DRB Application No.: 06DRB-01627 (P&F)

Project Name : LOS ALAMOS ADDITION

**DEVELOPMENT REVIEW BOARD  
TRANSPORTATION DEVELOPMENT  
Standard Comment Sheet**

DRB- 1005254                  Item No. 11          Zone Atlas F-14

**SITE PLAN OF
 PROPOSED LOTS 85-A & 85-B
 LOS ALAMOS ADDITION
 T. 11 N., R. 3 E., N.M.P.M.
 ELENIA CALLEGOS GRANT
 CITY OF ALBUQUERQUE
 BERNALILLO COUNTY, NEW MEXICO
 JANUARY 2007**

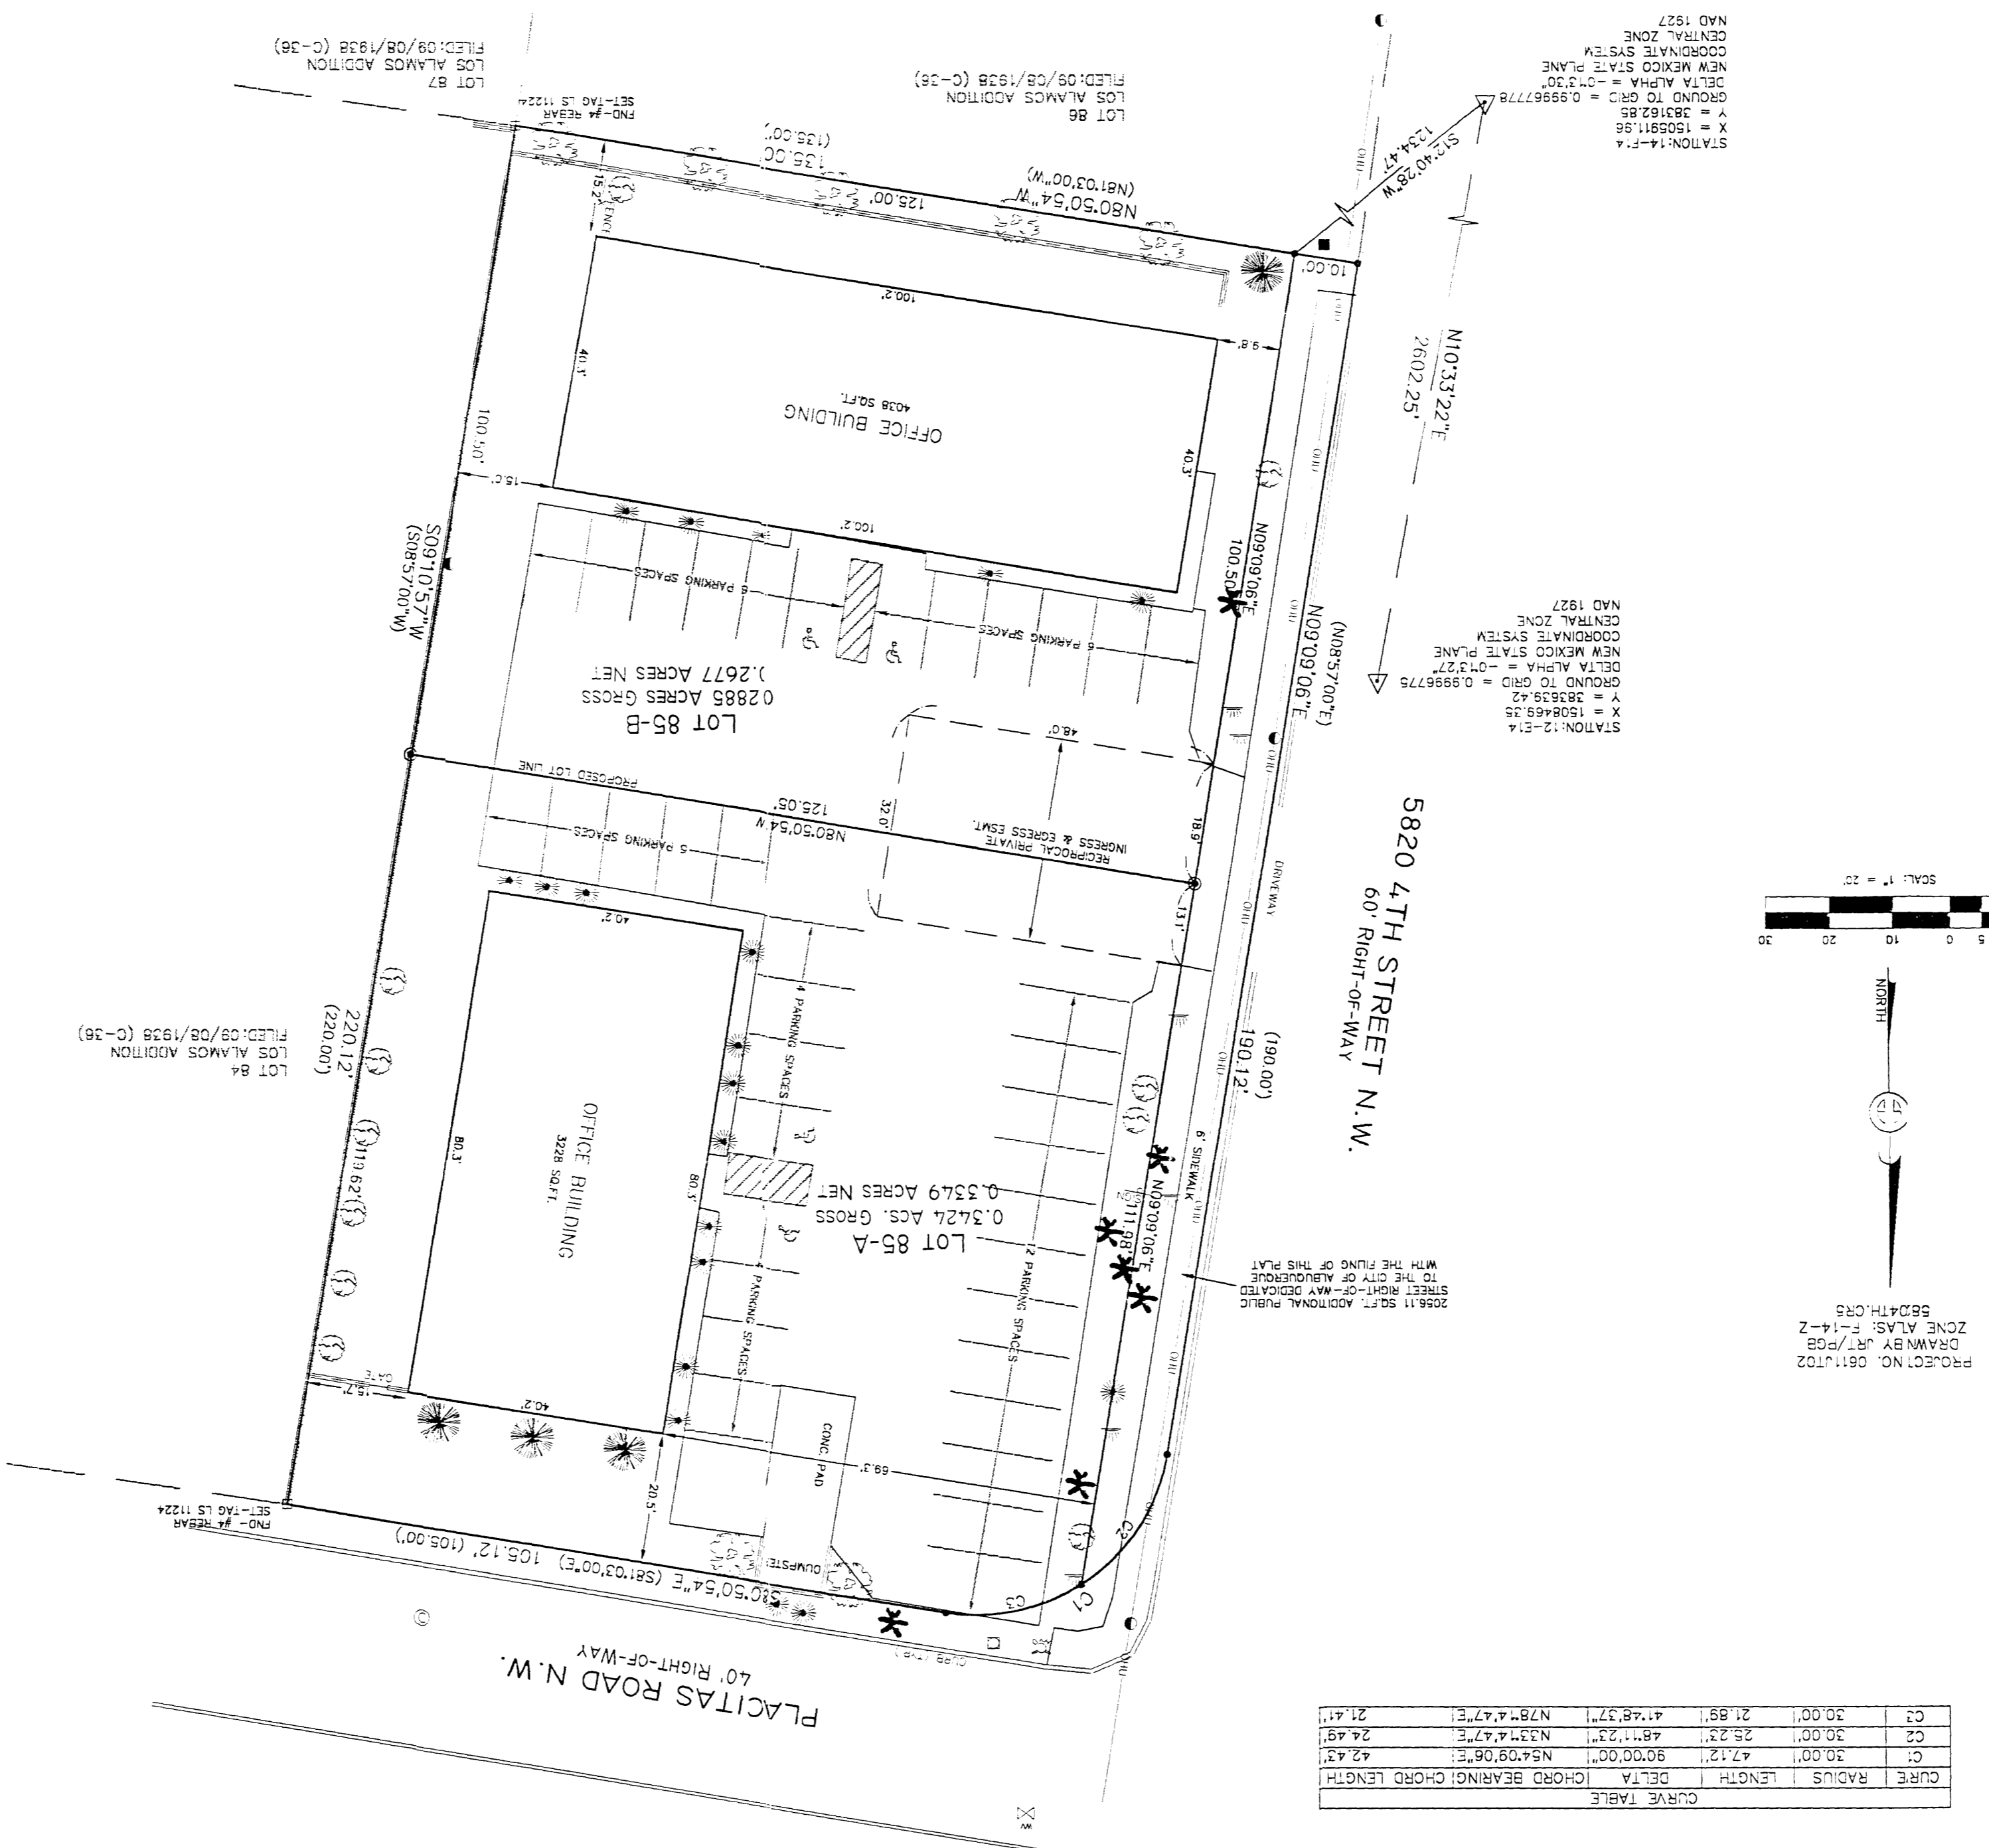
TRANSPORTATION: 4' sidewalk installed

- 1) Is there a sidewalk along Placitas?
- 2) The x-access should extend along the drive aisle.
- 3) A parking analysis is required.
- 4) Is there a site plan that needs to be amended?
